From: Michael Eastham <Michael.Eastham@arun.gov.uk>
Sent: 13 April 2020 11:18
To: Planning.Responses <Planning.Responses@arun.gov.uk>
Subject: FW: FP/103/19/PL - Land North of Felpham, Bognor Regis, West Sussex

From: Joe Russell-Wells <Joe.Russell-Wells@arun.gov.uk>
Sent: 28 May 2019 15:44
To: Michael Eastham <Michael.Eastham@arun.gov.uk>
Subject: FP/103/19/PL - Land North of Felpham, Bognor Regis, West Sussex

The following comments relate to DWG D1530 L320 REV E

Drg No: D42/5250/CFB/SL-01. Rev.E.

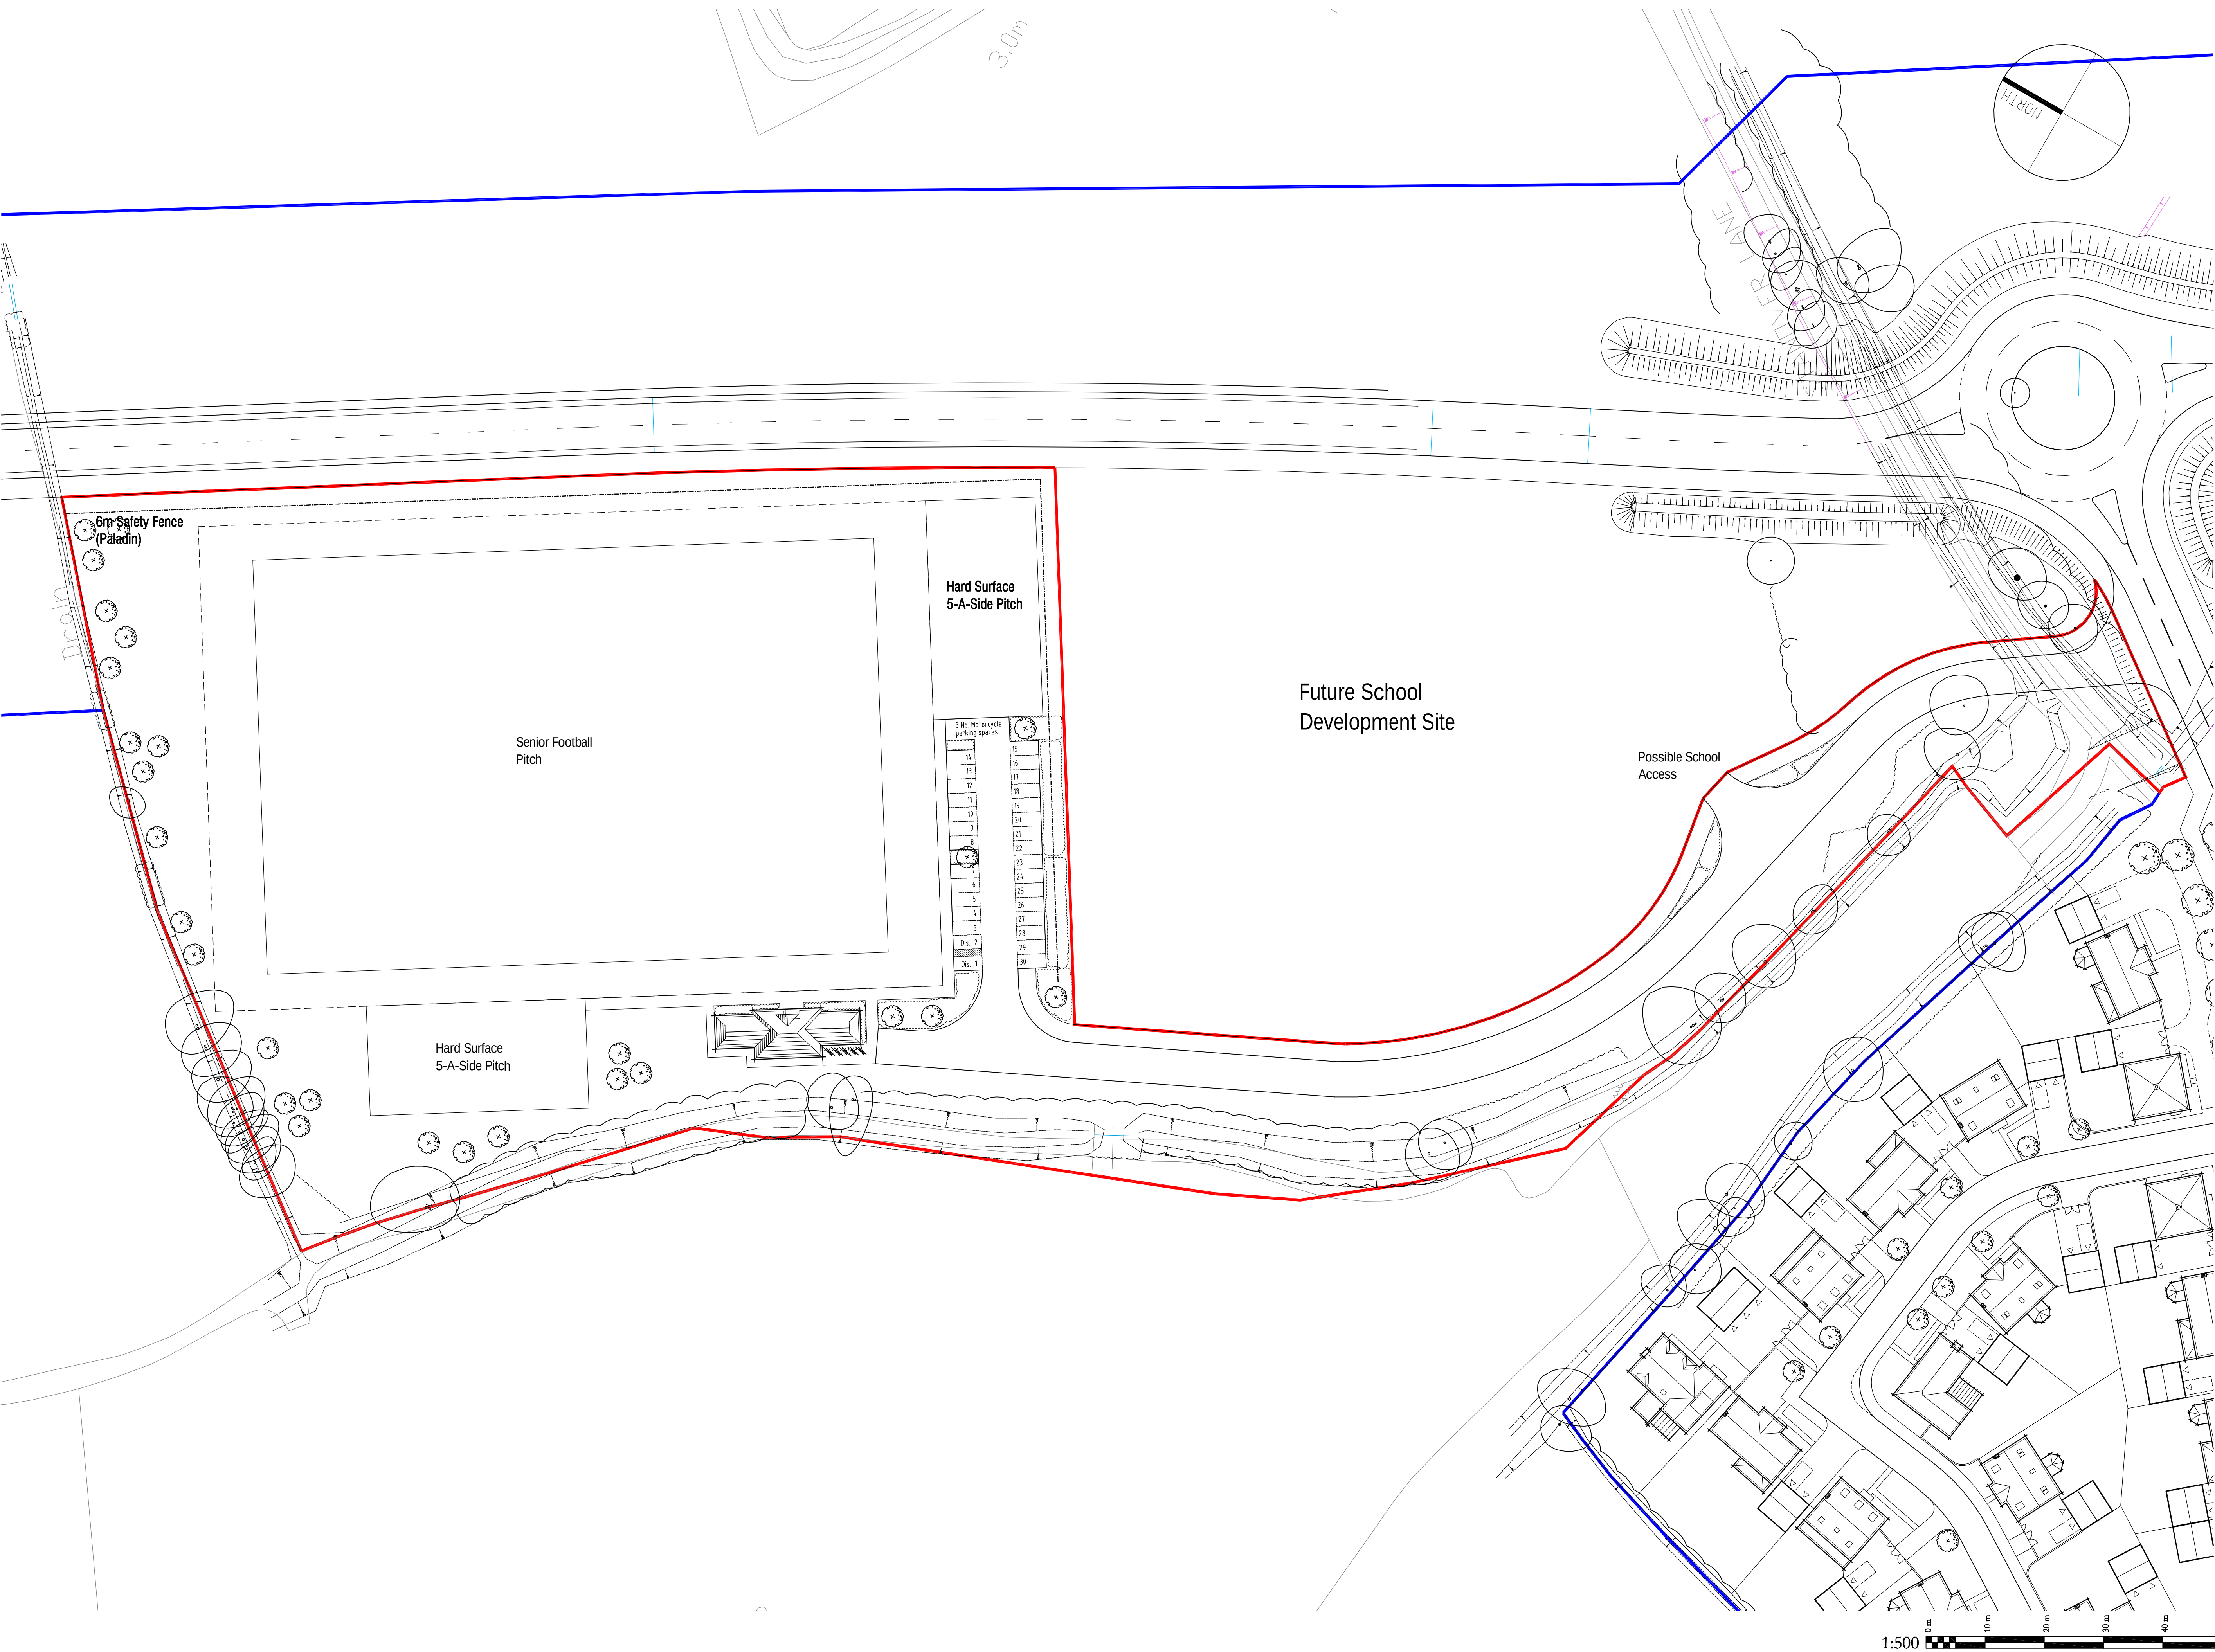
- The use of a cycle shelter (FT3) at this location is not appropriate – individual steel (stainless or similar) would be appropriate.
- Detail dwg to illustrate fencing (Boundary type 2) and security gate (FT2) for approval is required. Alternative to Boundary type 2 such as railway sleepers and a bund would be acceptable – detail to be approved.

- Detail of height barrier at FT1 to be approved – to include a gate to enable closure of car park.
- Specification of all tarmac surfacing, including sectional drawings and drainage must be provided for approval.

- Confirmation on the location of disabled parking – and that all areas to be line marked is required
- There is no reference to the boundary fencing detail for large parts of the site – this must be provided. The site boundary must be clearly established on the ground in all areas.

- Allow for surfaced pedestrian access (tarmac or similar approved surface) at northern part of site to link with the pedestrian footpath onto the new relief road – detail drawing to be approved – this will need to allow for measure to prevent the access of vehicles.

- Provision of site furniture such as seating, picnic tables, bins and dog bins to be provided on site – detail and locations to be approved.
- Allowance for the provision of interpretation and access signs – details to be approved – is required.

- Drawing needs to identify existing native planting to relief road boundary – on the noise bund and either side of the acoustic fencing.

- Details of standard tree planting is required – specified species is not clearly identified – this must be provided for approval.
- Addition tree planting adjacent to the car park area is required.
- Additional native planting is required beyond the standard tree planting illustrated – similar in specification to the relief road planting. This need to be provided in substantial areas adjacent to the site boundary.
- Two section drawings illustrating the levels across the site – including the access road / car park area is required for approval. Particular attention needs to be given to ensure levels marry in with surrounding landscape – particularly in areas where the ground is made up. Areas of ground must not be compacted; where this is evident in future years the developer will be required to make good.
